Application No: EP/71/26/HH
Site Address: 51 Warren Crescent East Preston BN16 1BL
Description of works: Extension to the side and infill extension to the rear, new roof and loft conversion and alterations to fenestration including removal of front porch.

Thank you for your internet representation made on 19th August 2026 which has been recorded as an objection with the comments as follows:

Project	ARCH2026_WaCI-R	Sheet
Date	30.06.2026	A105-C
Scale	as stated	
PLANNING ISSUE

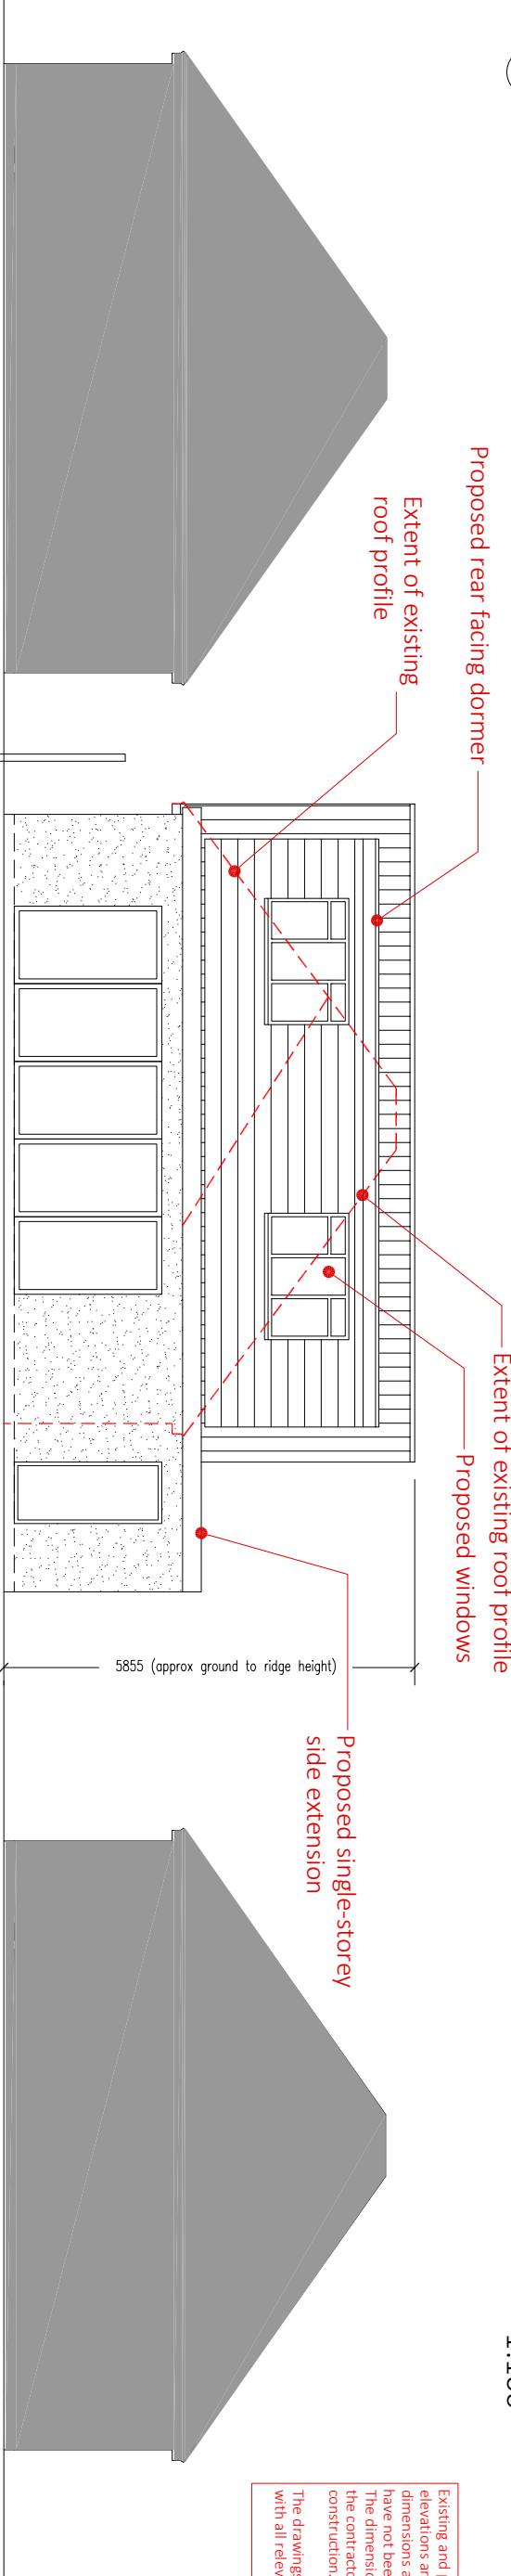
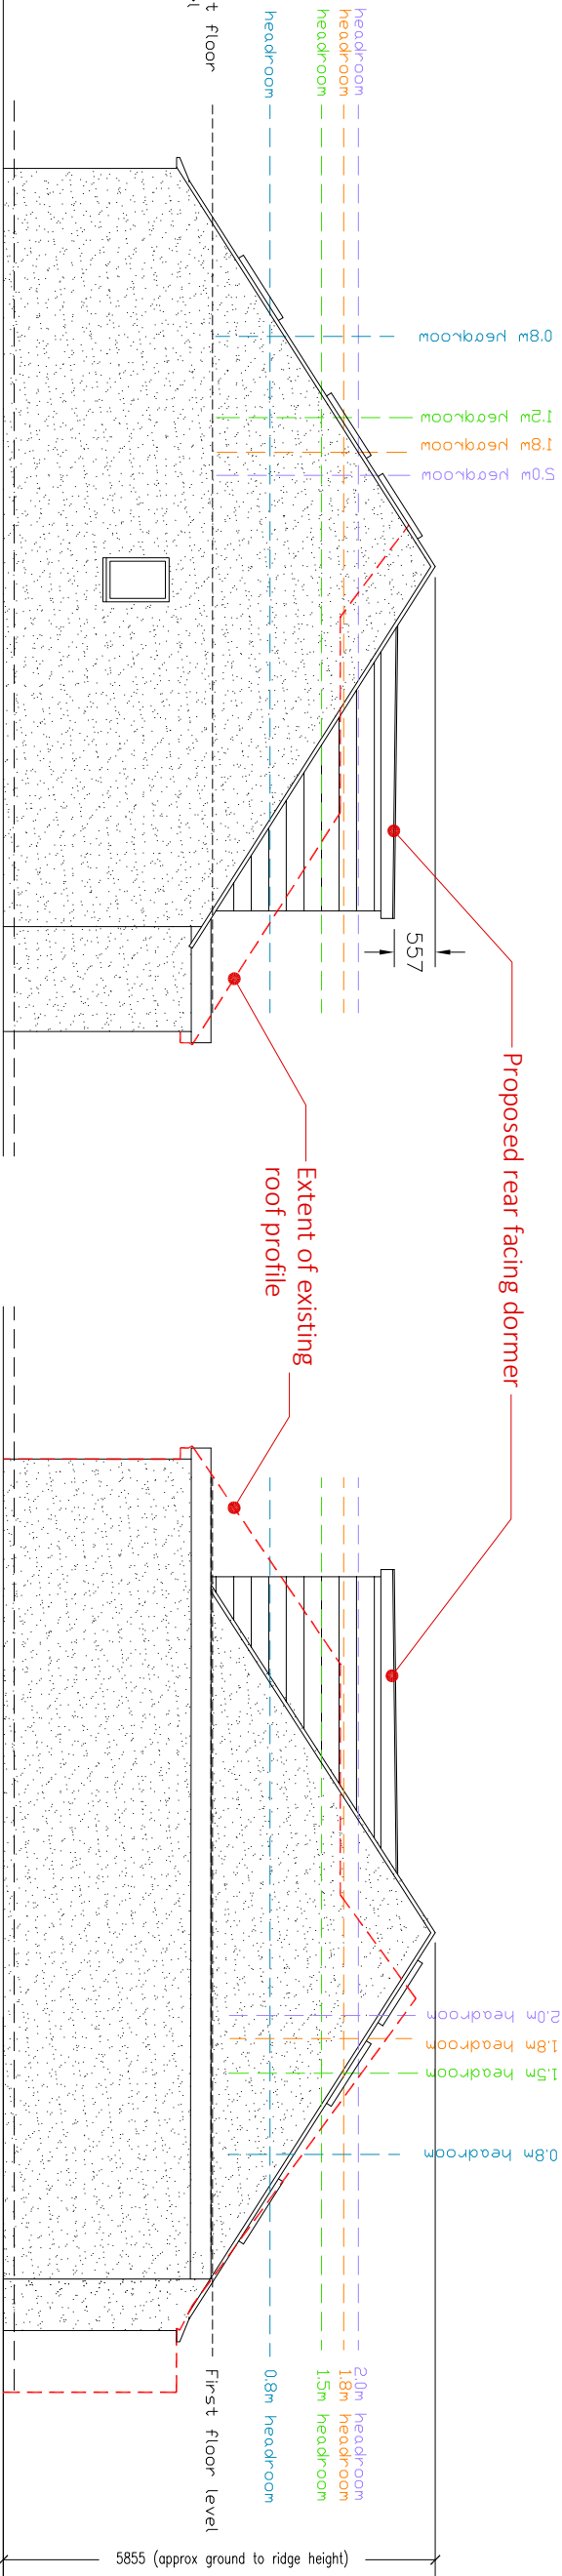
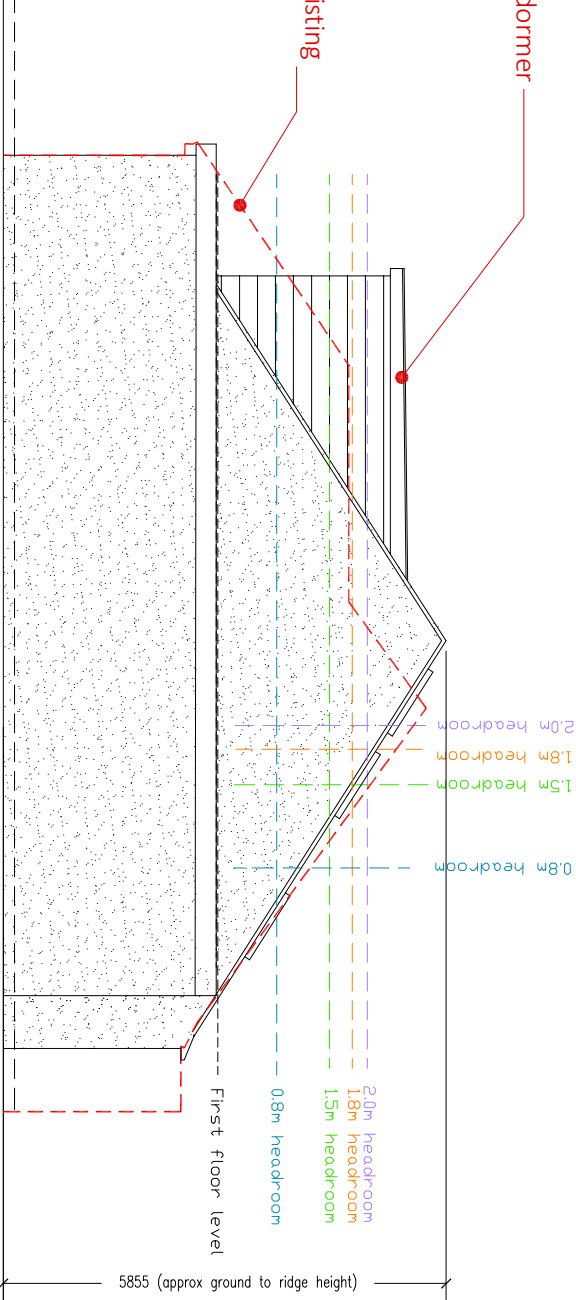
The proposed extension, loft conversion and removal of front porch and bay windows is completely out of character for the road. Neighbouring bungalows all have a sloping roof in keeping with the 1930's style. The changes proposed are starkly angular and box like, completely unsympathetic to anything in the road. The rear extension windows in the loft conversion would result in my garden being overlooked. It should also be noted that the address on most of the architectural drawings and plans is written as 51 Warren Close.
